Grandview Reserve Phases 2 & 3  
Preliminary Plan & PUD  
Traffic Impact Analysis  
PUDSP-23-006 & PUDSP-24-001  
(LSC #S234340)  
August 13, 2024

# V3\_TIS.pdf Markup Summary

SHEET TYP 02

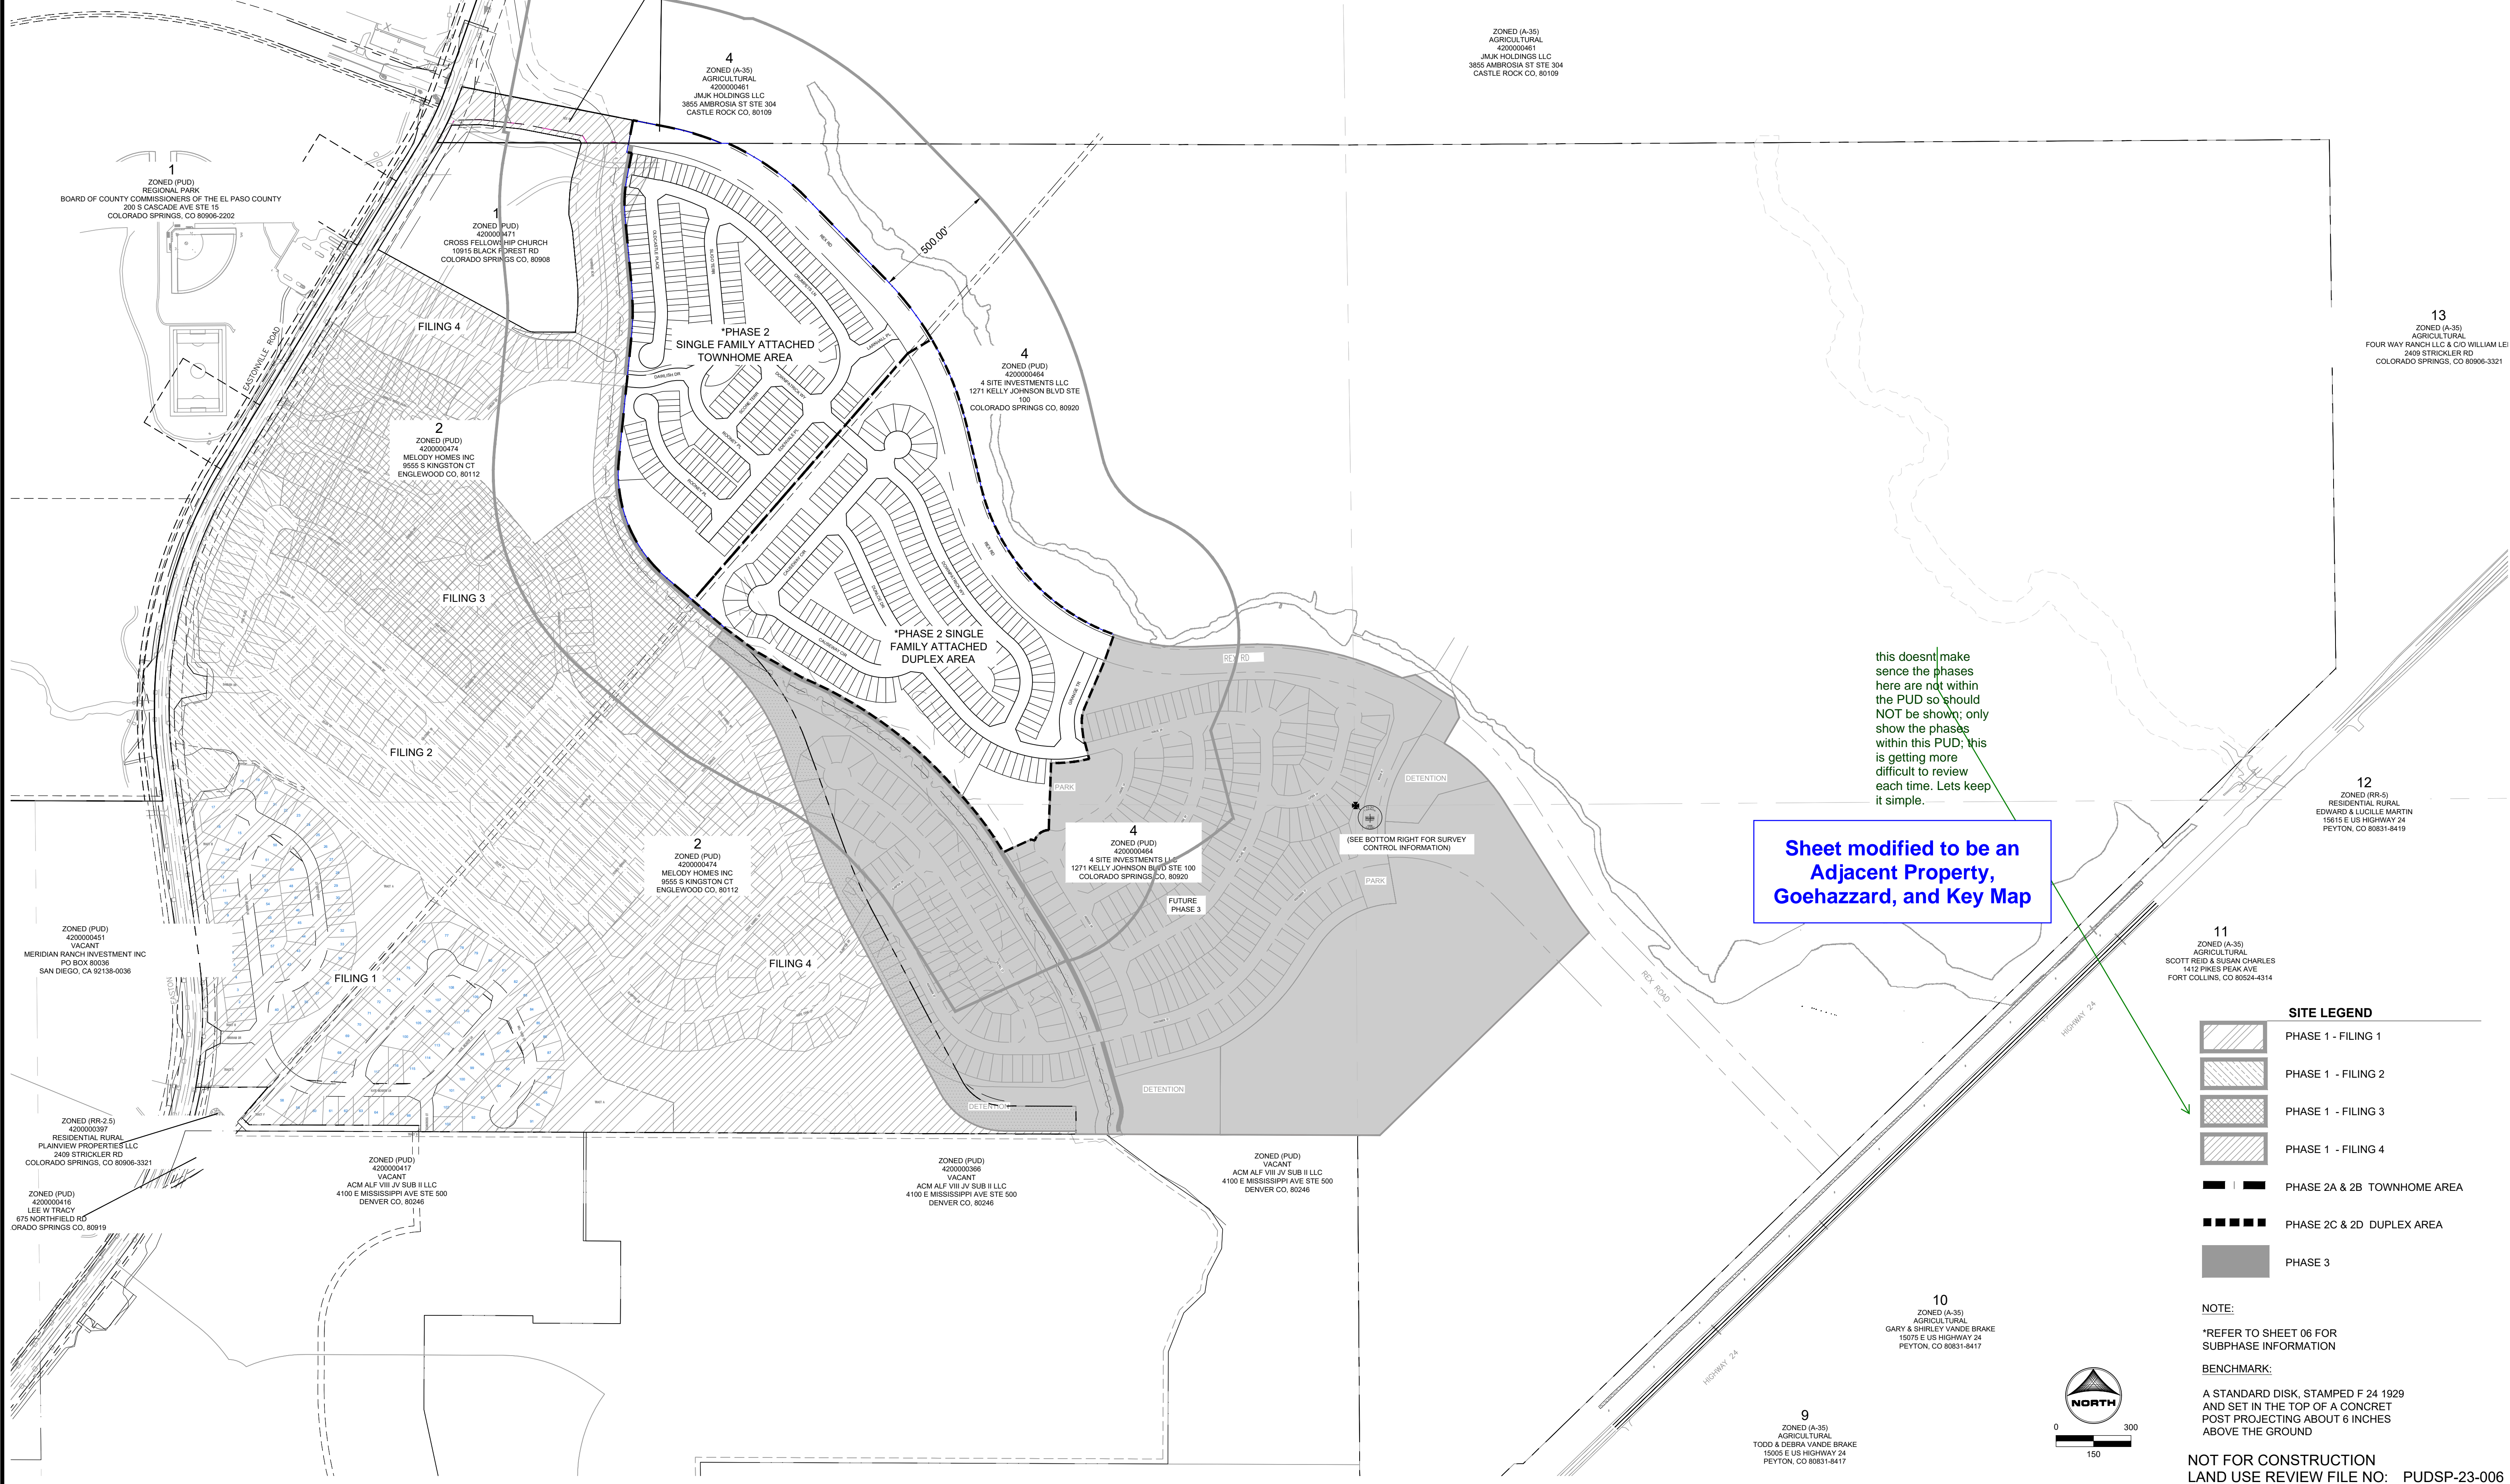
Please submit this deviation; did not see it with this round of submittals

typical Urban Local cross section: The roadway where this modified section would be

HRG Response:  
Deviation submitted with this resubmittal
